Letter No. A2/25956/96.

Sub: ~~MMDA~~ - Chennai Metropolitan Development
Authority - Planning Permission -
Construction of Ground Floor residential
building at Plot No.172 in S.No.152/2 of
Koladi village - Development charges and
other charges to be remitted - Regarding.

Sub: MMDA - Planning Permission - Construction of G/F
residential/commercial building at S.No. 152/2
Plot No. 172 Poor No. of Koladi
village, particulars called for - regarding.

GROUND FLOOR PLAN

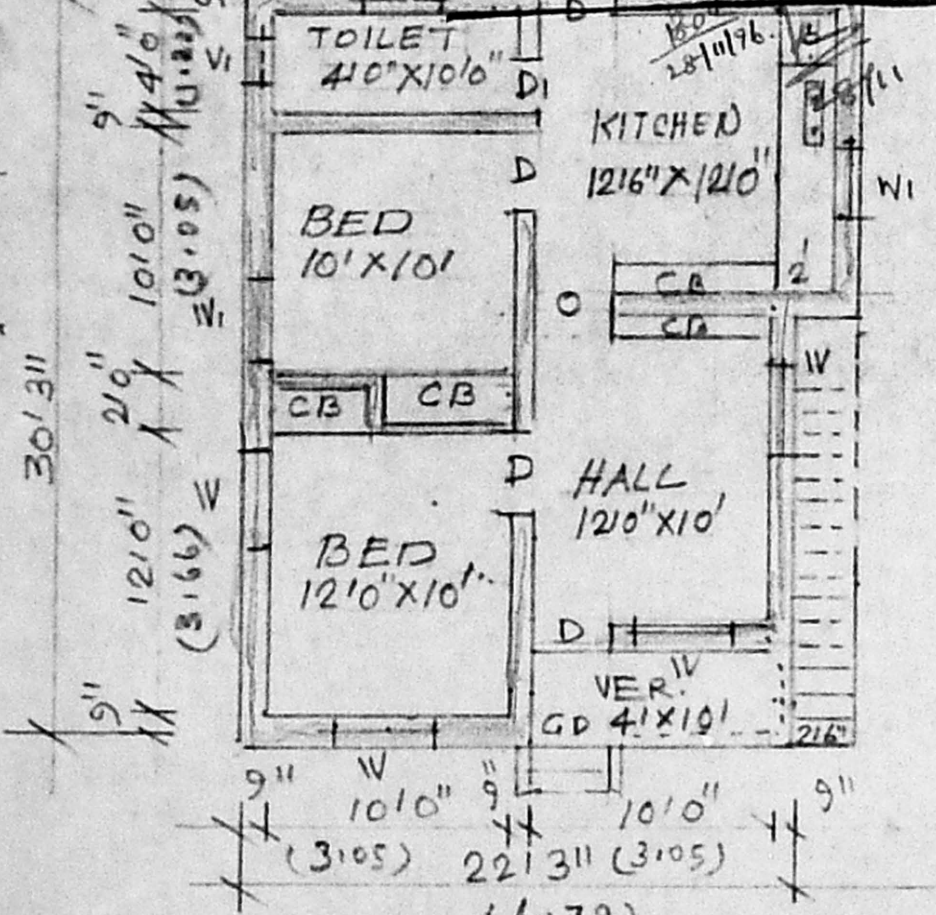
- a) Rain water conservation regulations stipulated by MEDA should be adhered to strictly.
- b) **Five sets of revised plan tallying the break-up measurements with over all measurements in the southern side of Building plan and also incorporate the side set back measurements of 15'9" in site plan on western side.**

remit the amounts and to furnish five sets of revised plan (X)
tallying the breakup measurements with overall measurements.
In the southern side of Building plan & also incorporate the
side set back measurements of 13'-9" in site plan on western side.

(X) is detecting the unitary
width in the basement side,
as 24'-3" is instead of 24'
The set back measurement
in western side is also to be
shown mentioned. o/c
